**Maryvale Solar Farm-Mod-1 (SSD-8777-Mod-1)**  
**Request for additional information**

I refer to the application for the Maryvale Solar Farm Modification 1. The Department is requesting that you provide additional information addressing the items below:

FIGURE 12: SENSITIVE RECEIVERS MAP

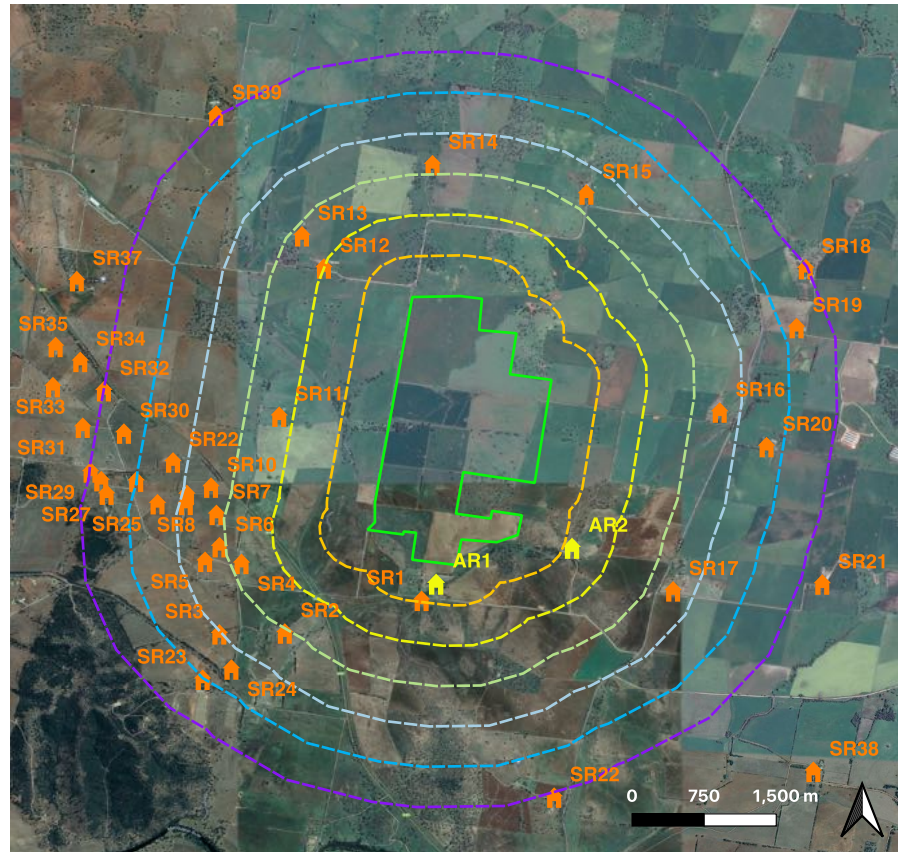
- confirm the number and location of all receivers surrounding the site and ensure this is consistent throughout the modification report and appendices; and
- provide appropriate figures (plans) indicating the location of surrounding receivers and separation distances (at 500 m intervals) from the project site, and ensure these figures are consistent throughout the modification report and appendices.
